## COMMUNITY SERVICES DEPARTMENT

September 29, 2022

Subject: Homestead North at Sterling Ranch Filing No. 3 Final Plat – Preliminary Comments (SF-22-029)

HOMESTEAD NORTH AT STERLING RANCH FILING NO. 3

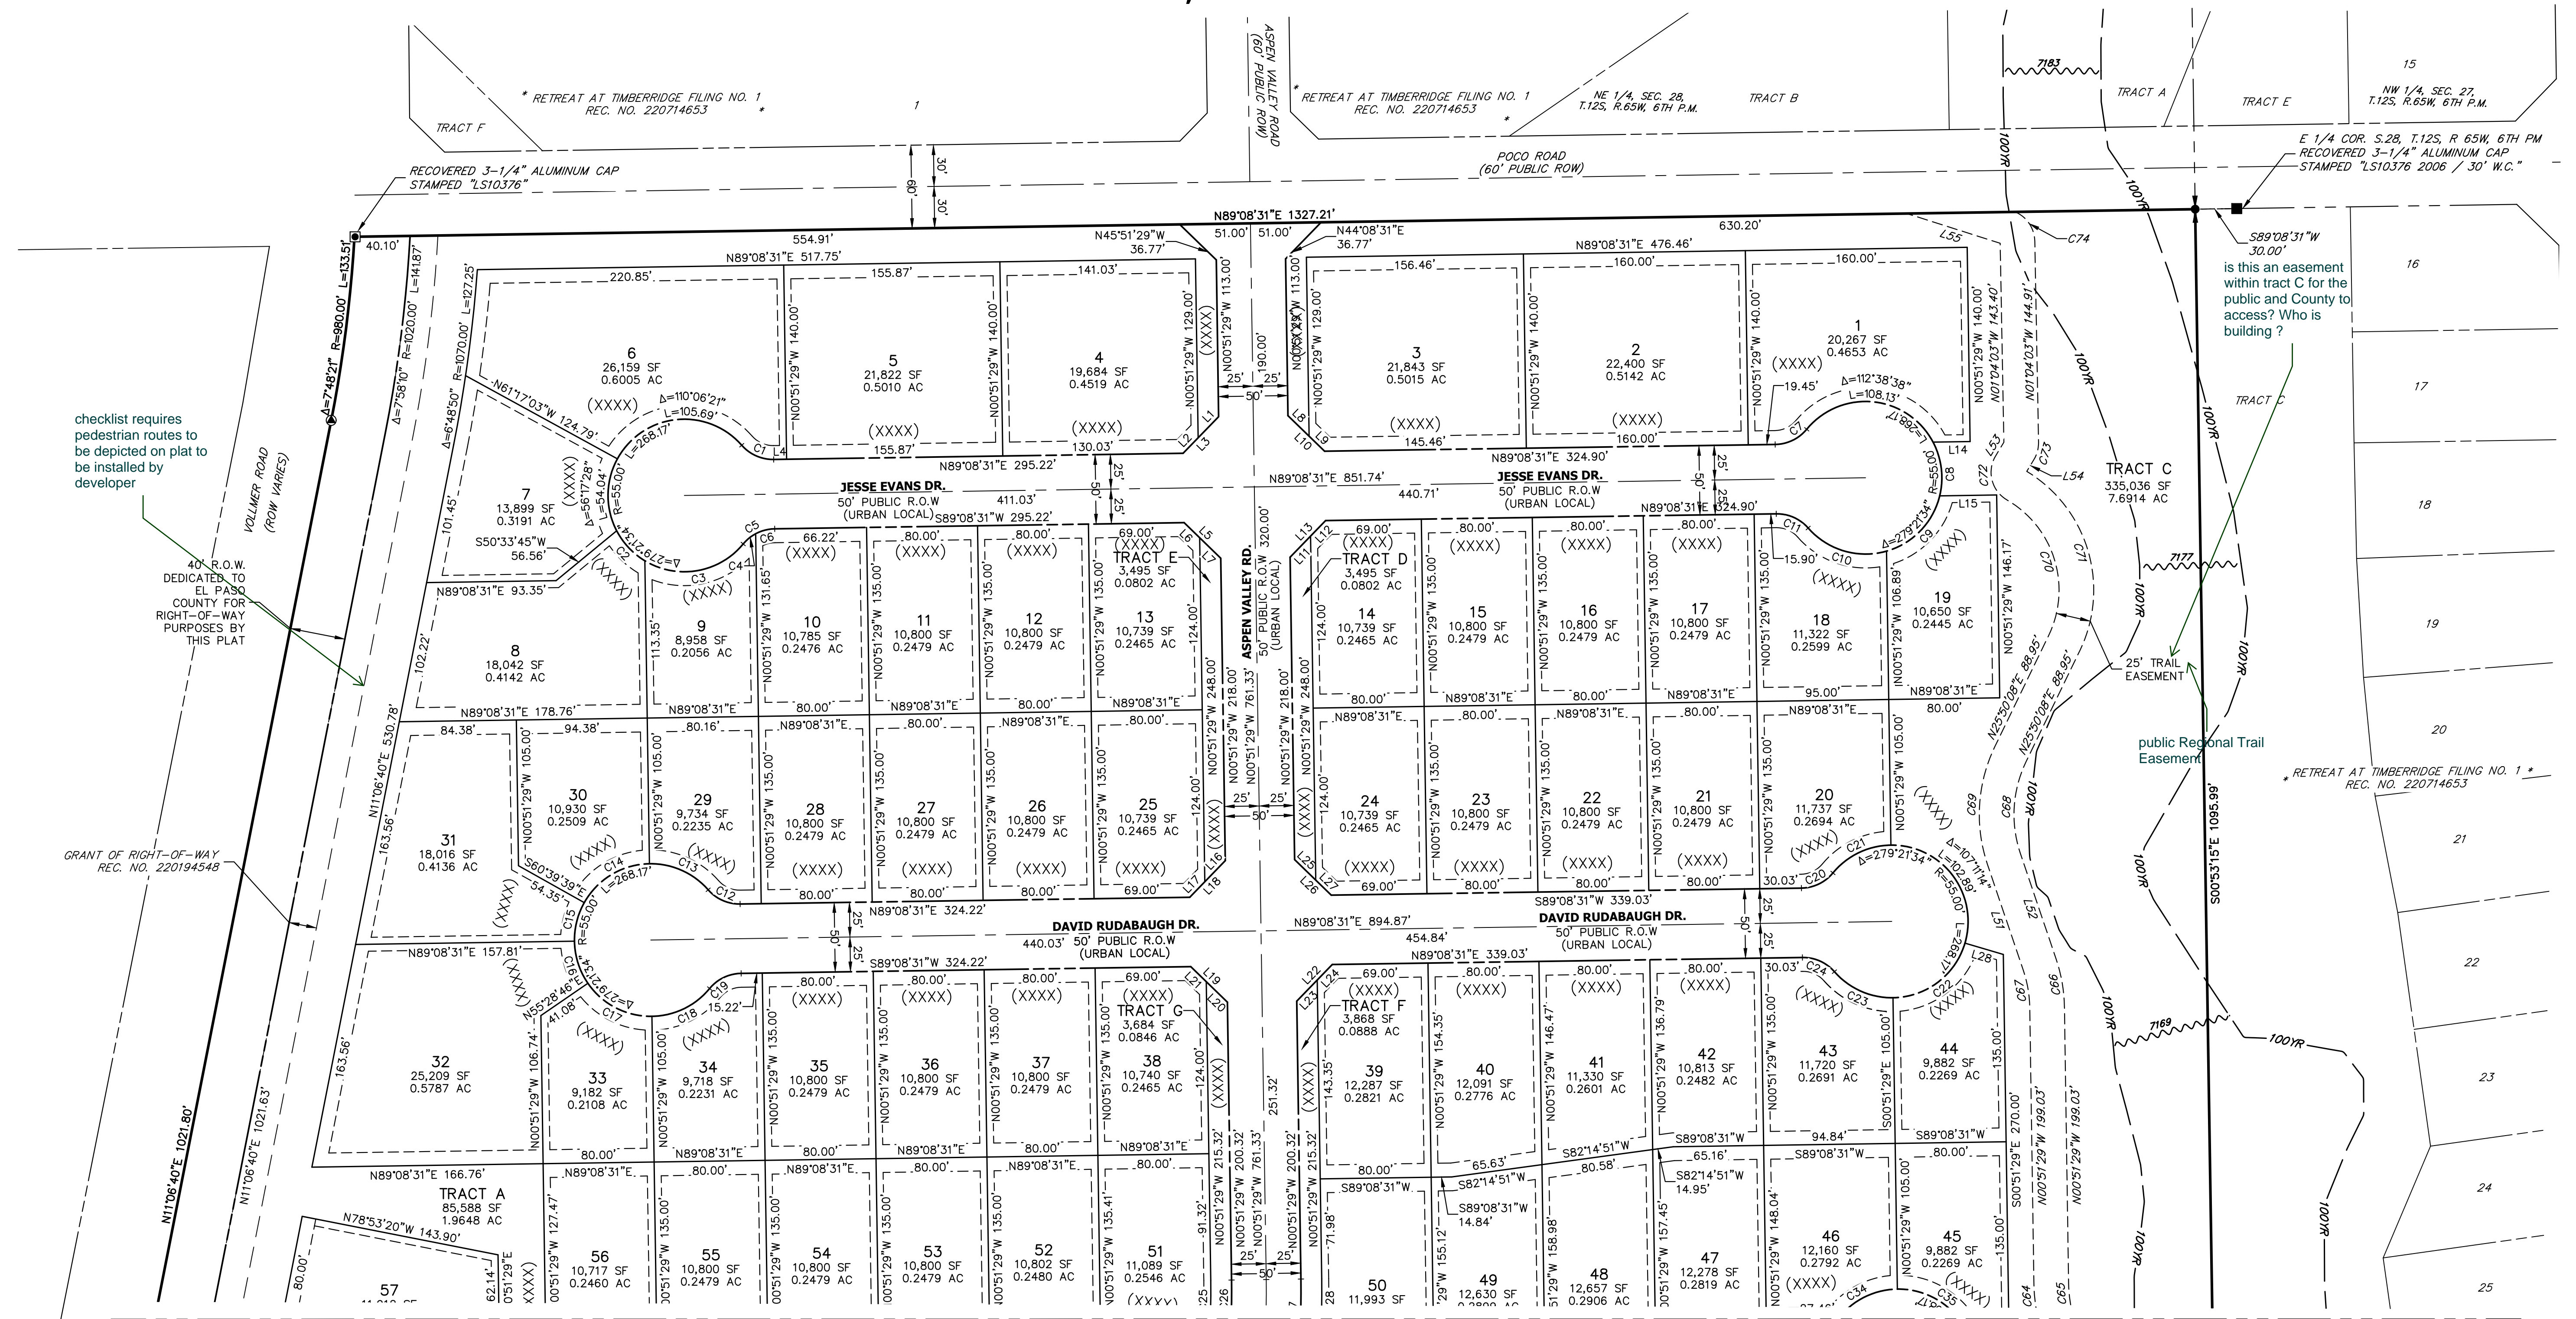
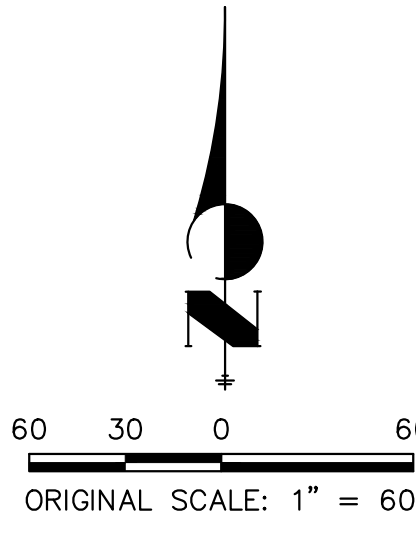
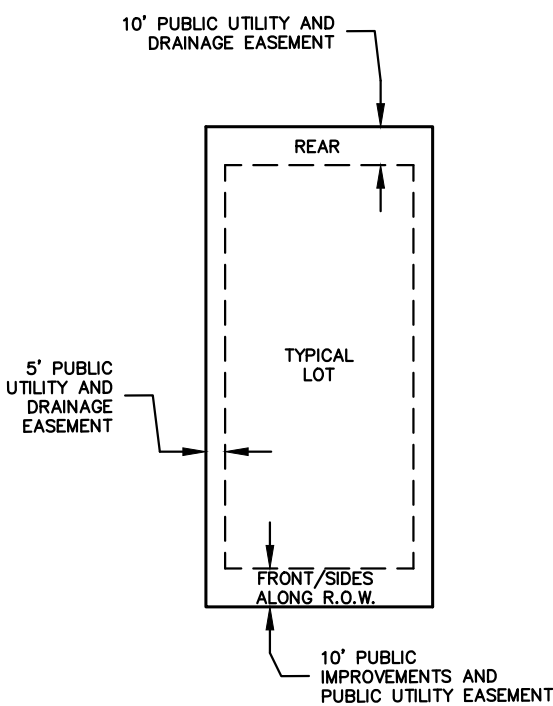
El Paso County Parks staff acknowledges and appreciates the inclusion of the 25-foot trail easement within Homestead North at Sterling Ranch Filing No. 3, Tract C. Because the Final Plat is not yet recorded, staff recommends that the applicant continue to designate, provide, and dedicate to El Paso County a 25-foot trail easement that allows for public access, as well as construction and maintenance of the regional trail, and show the dedication on all future submittals of the Final Plat application. Furthermore, staff recommends fees in lieu of land dedication for regional and urban park purposes.

The Park Advisory Board recommends that the Planning Commission and the Board of County Commissioners include the following conditions when considering and/or approving Homestead North at Sterling Ranch Filing No. 3 Final Plat: (1) designate and provide to El Paso County a 25-foot trail easement through Homestead North at Sterling Ranch Filing No. 3, within Tract C extending to its terminus at Poco Road, that allows for public access, as well as construction and maintenance of the Sand Creek Primary Regional Trail, and dedicate the easement to El Paso County prior to the recording of this Final Plat; 2) fees in lieu of land dedication for regional park purposes in the amount of \$35,420 and urban park purposes in the amount of \$22,330 will be required upon recording of this Final Plat.
